Re: Hagstrom Residence Critical Areas Report, Response to Peer Review Comments

The Watershed Company Reference Number: 160735

This letter represents our responses to the concerns and recommendations provided by the City's Peer Reviewer related to the recently prepared mitigation plan and Critical Areas Report for your property located at 7428 SE 71st Street in Mercer Island, Washington. The comments were provided in a June 8, 2017, letter from Environmental Science Associates (ESA) (*Hagstrom Review CAO17-004*). ESA's comments and recommendations are listed in italics below. Our response to the comments follow in standard font.

**PLANTING SCHEDULE**

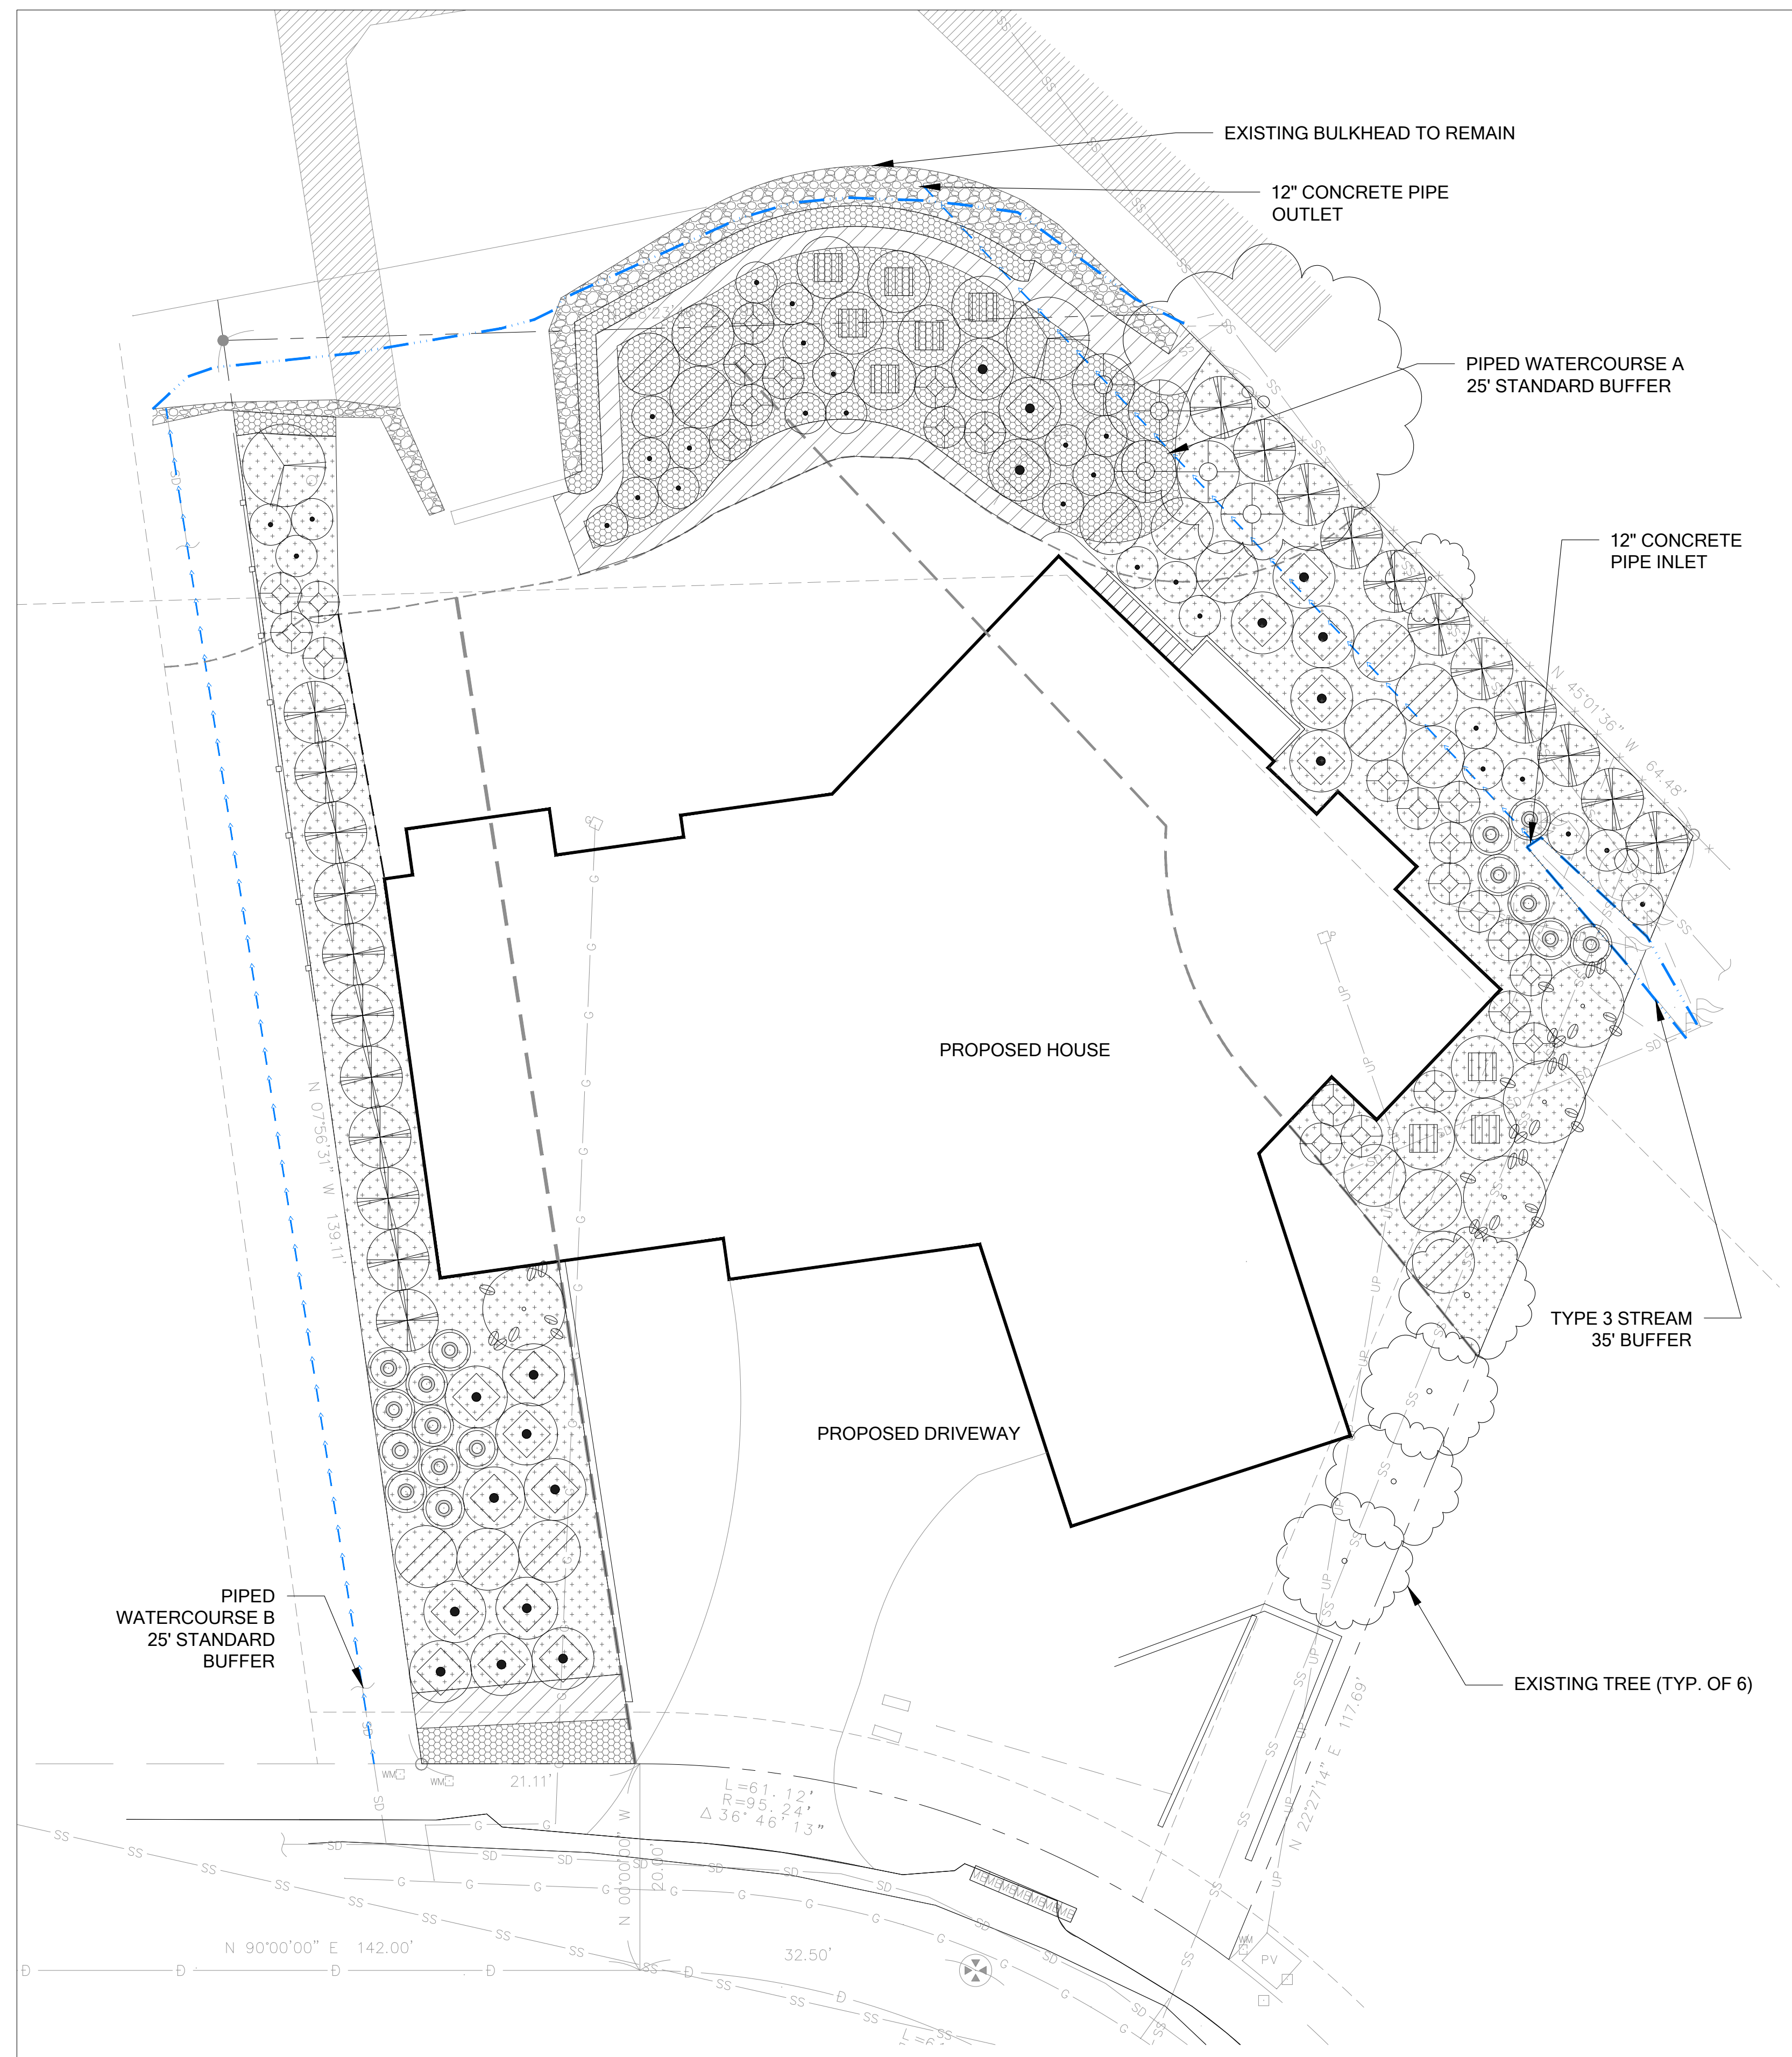
On the "second" sheet W4 of the drawing set (assuming it is meant to be sheet W5) there are ten (10) shrubs listed in the planting schedule, but on page 14 of the critical area study (section 6.1) it states that "nine native small tree/shrub species and five native groundcover species are proposed in the mitigation area."

Also on "second" sheet W4 hatched areas for groundcovers are shown beneath proposed shrub plantings. If the quantities listed for groundcovers in the planting schedule are calculated to be

planted at 24" O.C. across the entirety of these hatched areas, this would result in too many plants being planted on the site. This could be mitigated if the quantities been adjusted to leave room for the other plants on the plan.

There correct number of proposed shrub plantings is ten. The CAR has been revised to correct the inconsistency. The duplicate plan sheet numbers have been corrected.

The planting quantities and/or densities have been recalculated as requested. Groundcovers in the watercourse buffer enhancement areas, which include sword fern and low Oregon grape, will be spaced at 48" on center. Groundcovers in the shoreline buffer enhancement area, including kinnikinnick, western larkspur, and Roemer's fescue, are smaller species, which will be installed at 36" on center.
